A57 Link Roads

TR010034

**9.72 Addendum to the Statement of
Common Ground with High Peak**

March 2022

- LEGEND**
- MODELLED QUALIFYING FEATURES AND PUBLIC ACCESS
  - DEFRA PCM LINKS COINCIDING WITH ROADS MEETING THE DMRB LA105 TRAFFIC SCREENING CRITERIA
  - ROADS MEETING DMRB LA105 TRAFFIC SCREENING CRITERIA

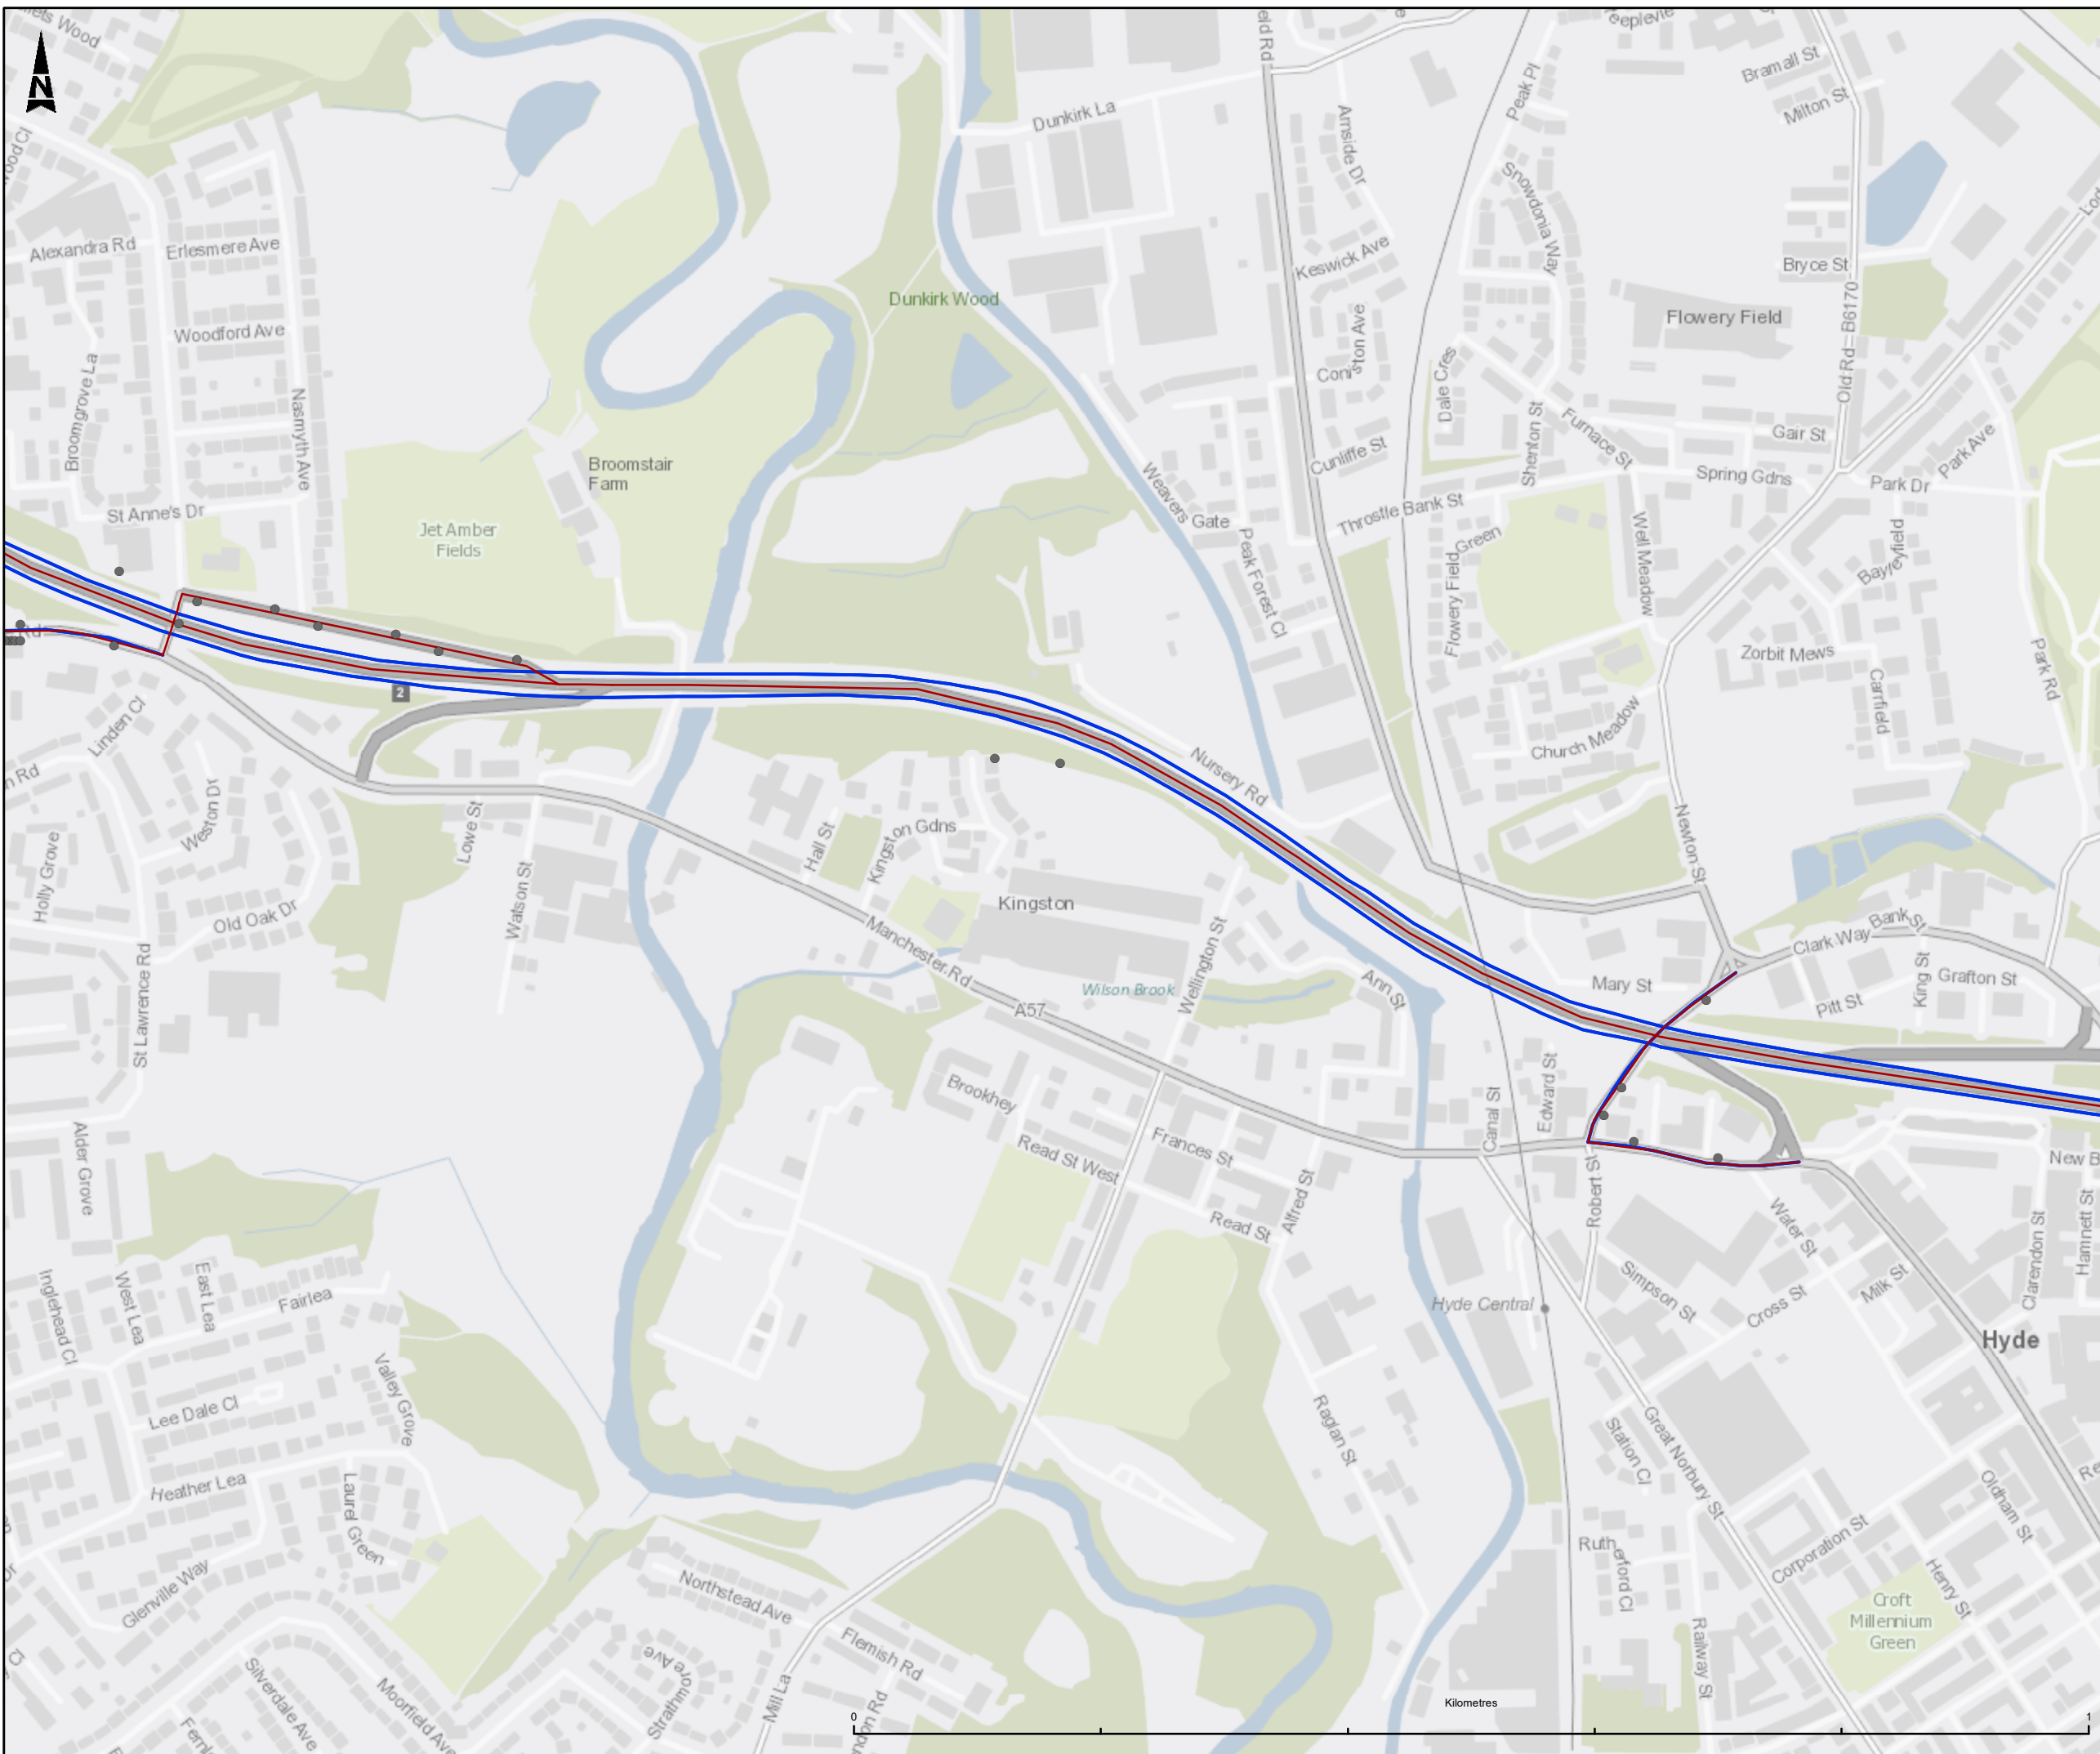
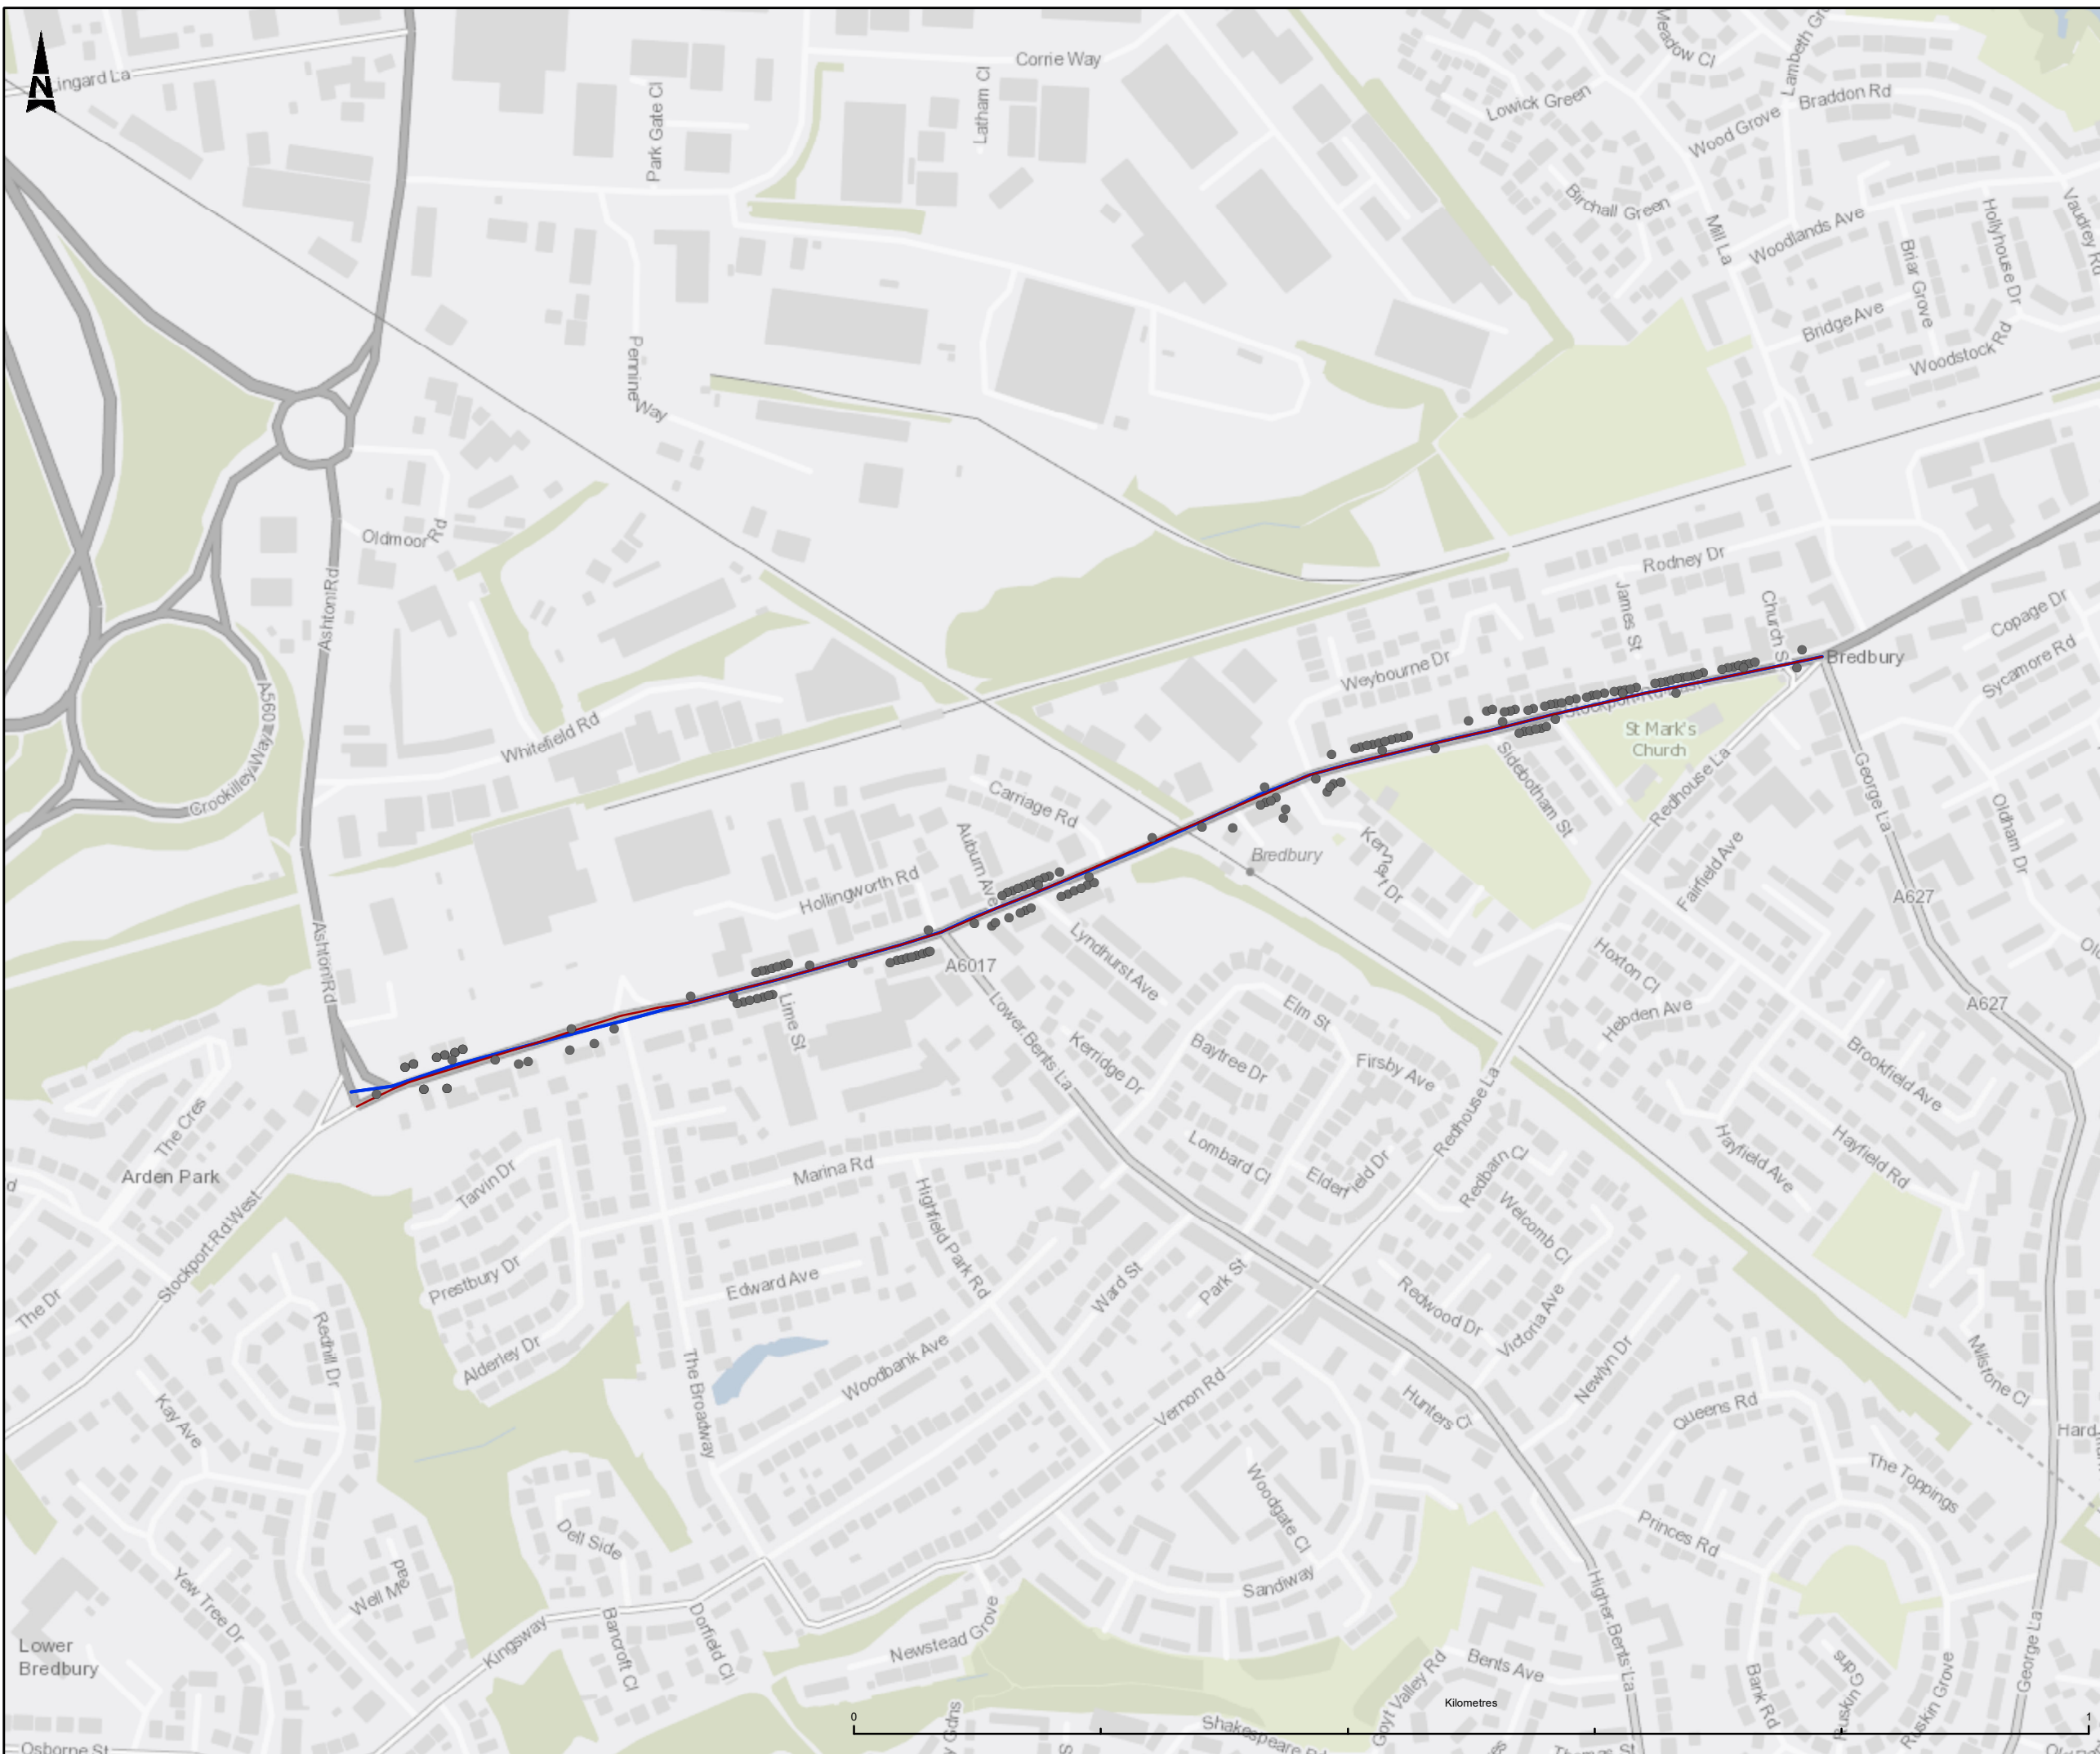
Figure 5.4 Air Quality Compliance Risk Assessment – receptor labels			
<p>Item 8.38 HPBC [REP4-011] asked for the A57 Brookfield qualifying features used in</p>	<p>Given the number of qualifying features and public access receptors included in the compliance assessment it was not</p>	<p>Agreed</p>	<p>Closed</p>

HPBC Item	National Highways Position	HPBC Position	Status
<p>the NO2 compliance assessment to be labelled on ES Figure 5.4 [APP-080].</p>	<p>possible to practically label the qualifying features in ES Figure 5.4 (APP-080) however, an extract of ES Figure 5.4 zoomed in on the A57 Brookfield area with receptor ID labels for qualifying features and public access receptors adjacent to the A57 Brookfield is provided below this table.</p>		
<p>Adjustment of Background Concentrations Data used in Air Quality Assessment</p>			
<p>Item 8.39 HPBC raised concerns about the lack of adjustment to the background concentrations used in the air quality assessment. HPBC [REP4-011] suggest they are concerned about over representation of beneficial effects.</p>	<p>The HPBC query relates to the verification and adjustment of the Department for Environment, Food and Rural Affairs (Defra) mapped background concentrations. National Highways provided a response to question 8.39 in REP3-018. As stated in REP3-018, where the Defra background maps underpredict background monitoring data this could lead to a need to apply a higher adjustment factor in the air quality model verification. The higher the adjustment factor applied, the more conservative the results of the assessment given that the adjustment is applied to both the modelled total concentration with and without the Scheme, which has the</p>	<p>Agreed</p>	<p>Closed</p>
